2 August 2021

**SSD-9351535, JOHN HUNTER HEALTH & INNOVATION PRECINT – 29 KOOKABURRA  
CIRCUIT NEW LAMBTON HEIGHTS**

### TfNSW Response

Figure 6 – Proposed Construction Access

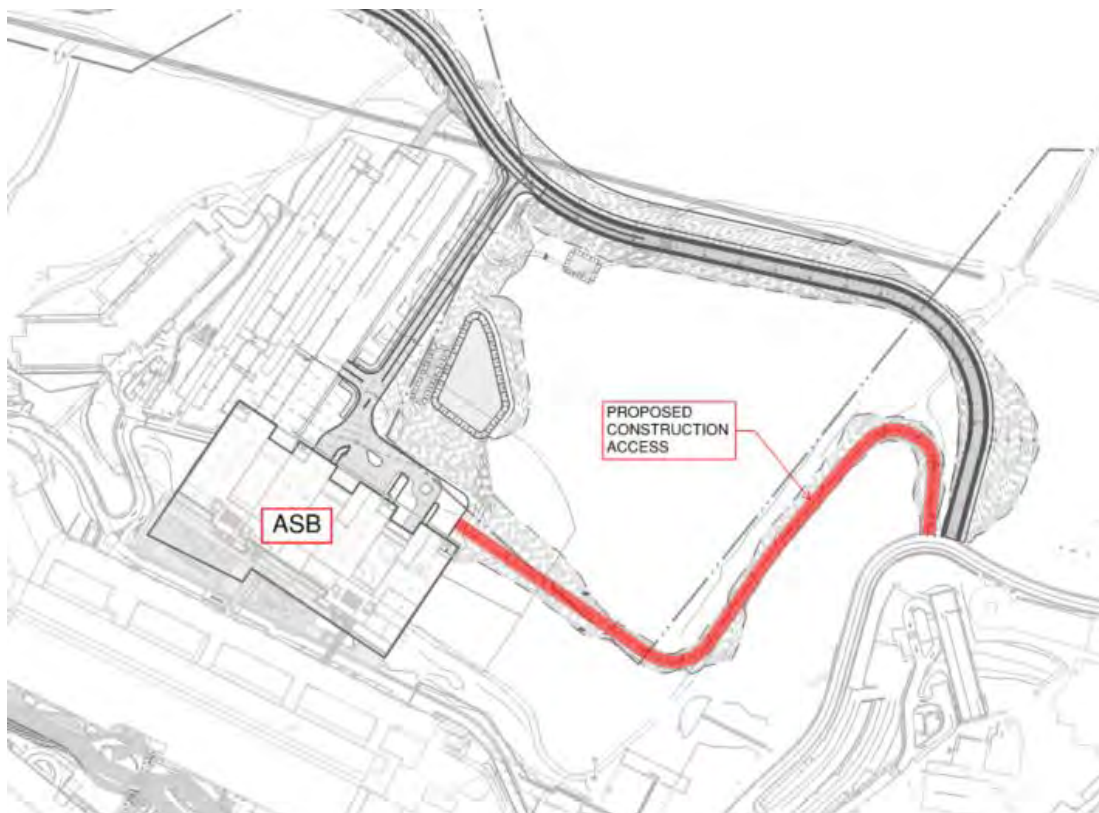
- Construction Site Access – The area near Carpark 4 has been identified to suit NICB works and land swap arrangements. This area is required to be dedicated to TfNSW, and at no cost to TfNSW, prior to the completion of the main works for NICB. The construction site access should thus be modified near Carpark 4 to suit this agreed arrangement.

Figure 11 – Onsite detention basin locations

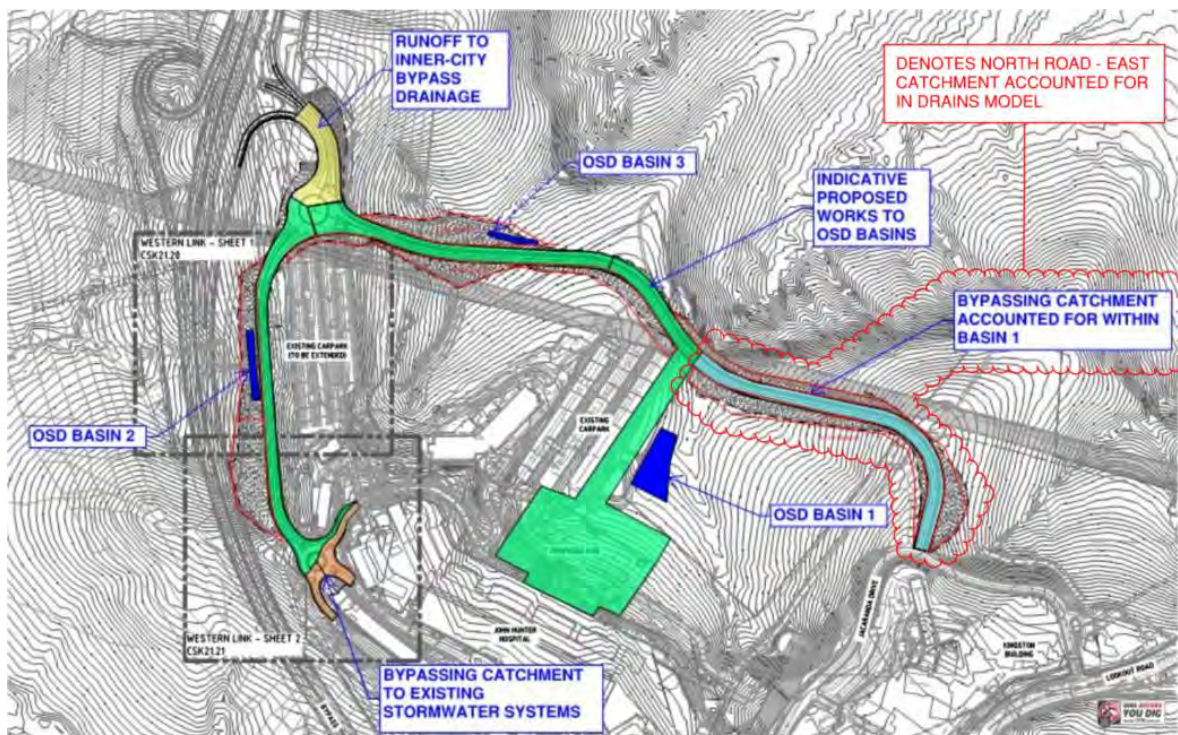
- Stormwater Management – A combined sediment / biofiltration / detention basin - number 2 - is located immediately upstream of the NICB (located on the eastern side). Discharged stormwater from this system shall not exceed the capacity of the stormwater drainage system identified in the current design, which is for swale / catch drain and stormwater

culvert system. This civil infrastructure is identified at Chainage 8630 of the concept Aurecon Design.
